DEVELOPMENT REVIEW BOARD
TRANSPORTATION DEVELOPMENT

DRB Project Number: 1011396
North Abq Acres-
Legacy Apt Ph. 2

SUBJECT: Site Plan for Building Permit

DRB Project Number: 1011396 Hearing Date: 03-14-2018
 Project: North Abq Acres Unit B, Tract A, Lots 1-3 & 30-32 – Legacy Apt 2 Agenda Item No: 5

LEGACY NAA APARTMENTS II CONCEPTUAL DRAINAGE PLAN

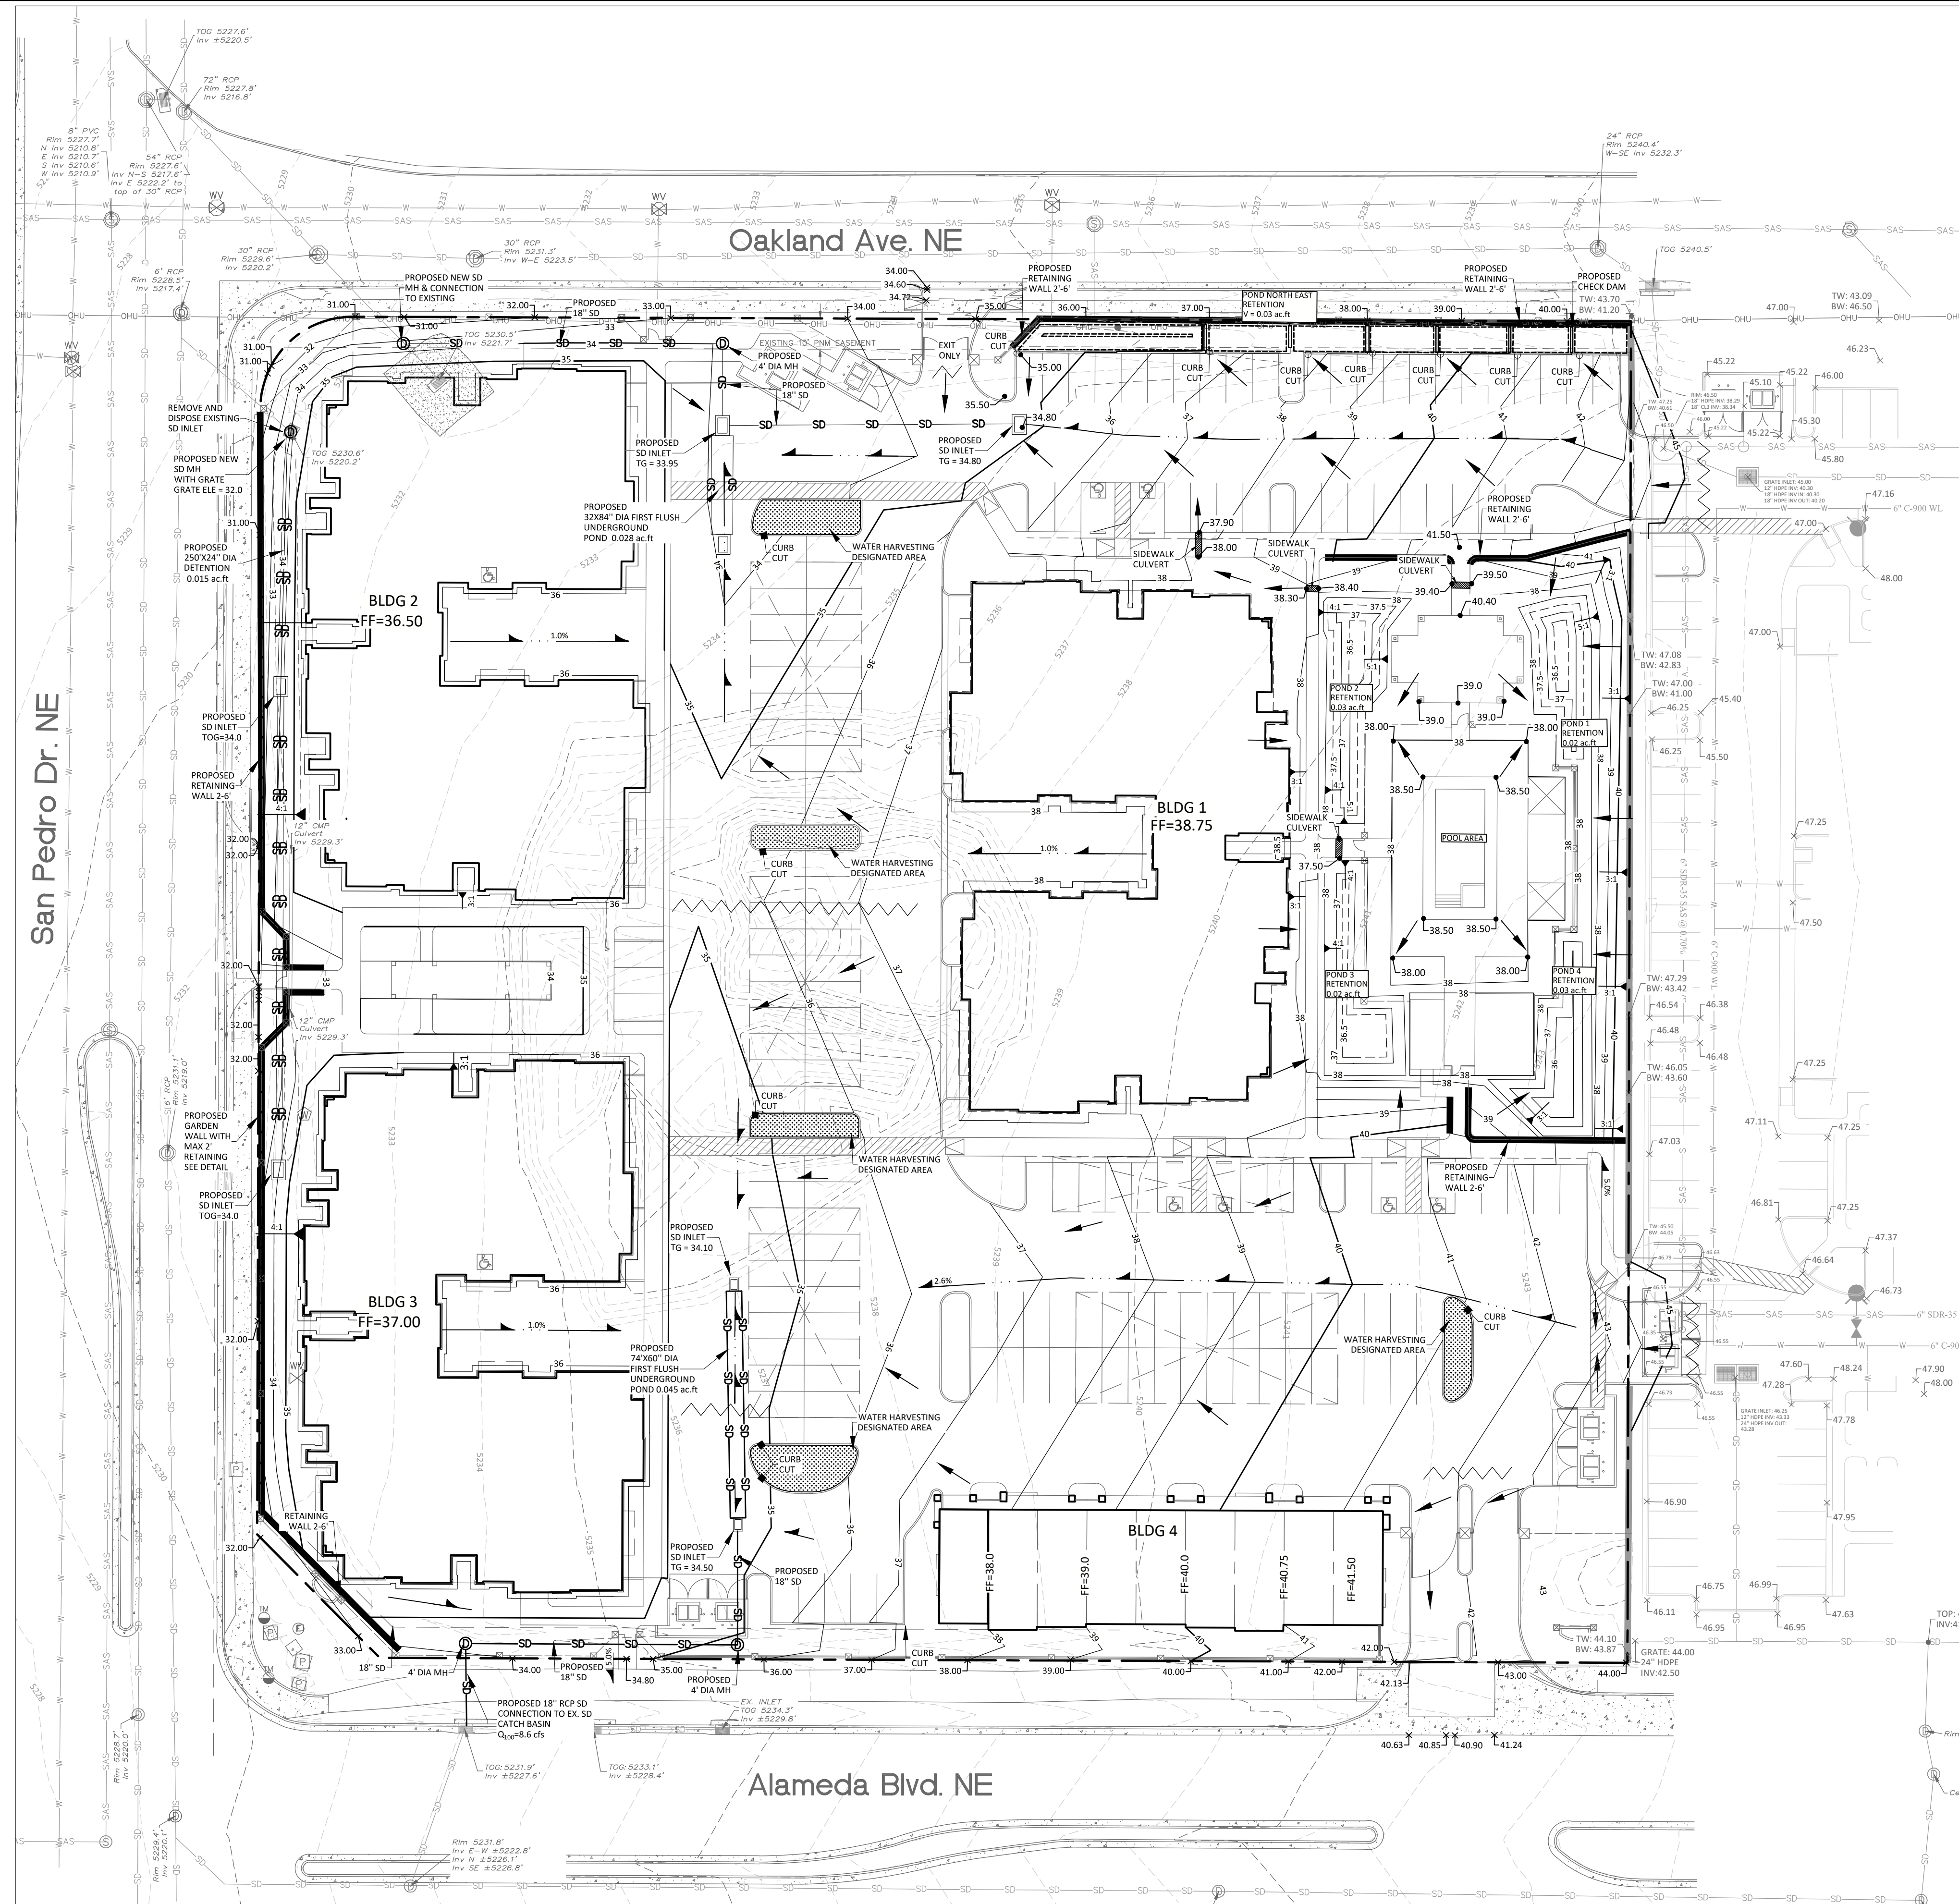
- Hydrology has an approved a revised Conceptual Grading and Drainage Plan with engineer’s stamp 03/07/18.
- The revised Conceptual Grading and Drainage Plan needs to be in the submittal.
- Hydrology can sign Infrastructure List.
- A recorded SIA is required prior to Hydrology sign-off of the SPBP.
